Rezoning Transportation Analysis

Petition Number: 2023-094

General Location Identifier: 02930129, 02930130

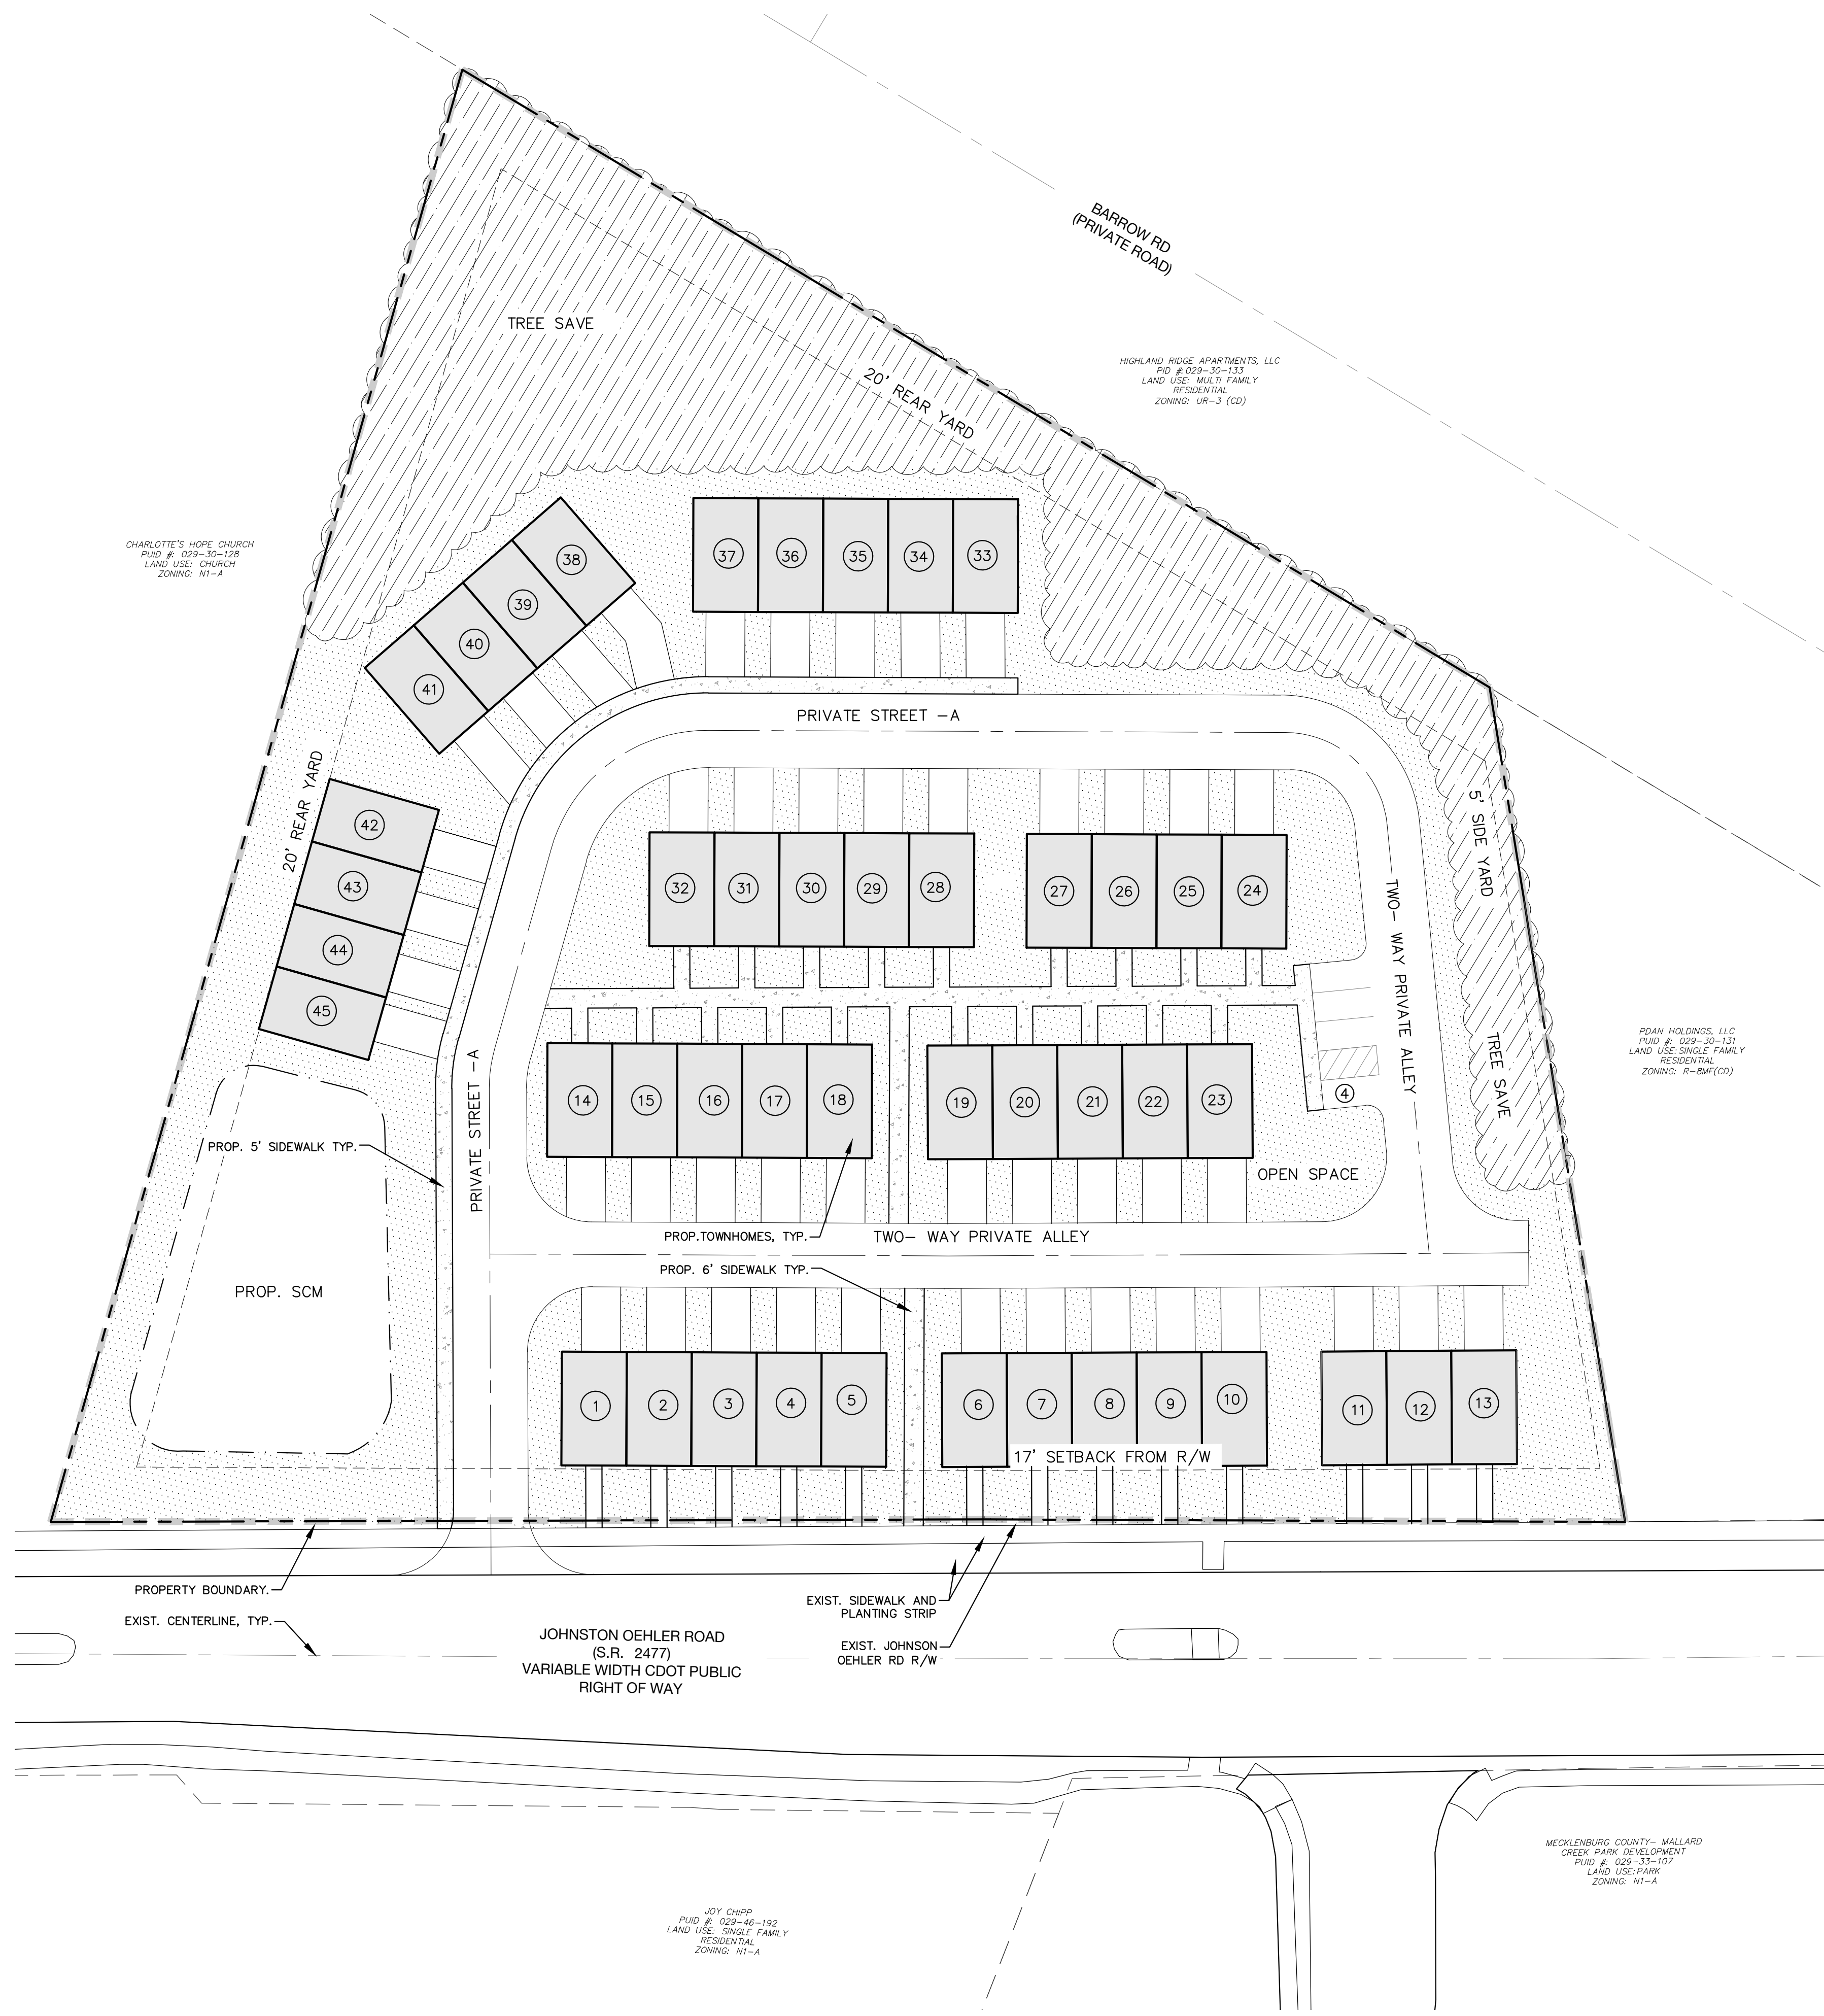
- a. **Road Name (Johnston Oehler Road):** the future location of curb and gutter is in its existing location.

Label and dimension the curb and gutter from the centerline for each road on the site plan.

3. Revise site plan and conditional note(s) to commit to dedicating a min of 35-feet of right-of-way from the road centerline. The site plan shall label and dimension the right-of-way from the road centerline.

5. Revise site plan and conditional note(s) to commit to lining up driveway with driveway on the Southern side of the roadway.
6. **CDOT REQUEST from 09-28-23:** Revise site plan and conditional note(s) to commit to installing a signalized pedestrian crossing at the existing pedestrian crossing location that would allow for connection to Mallard Creek High School.
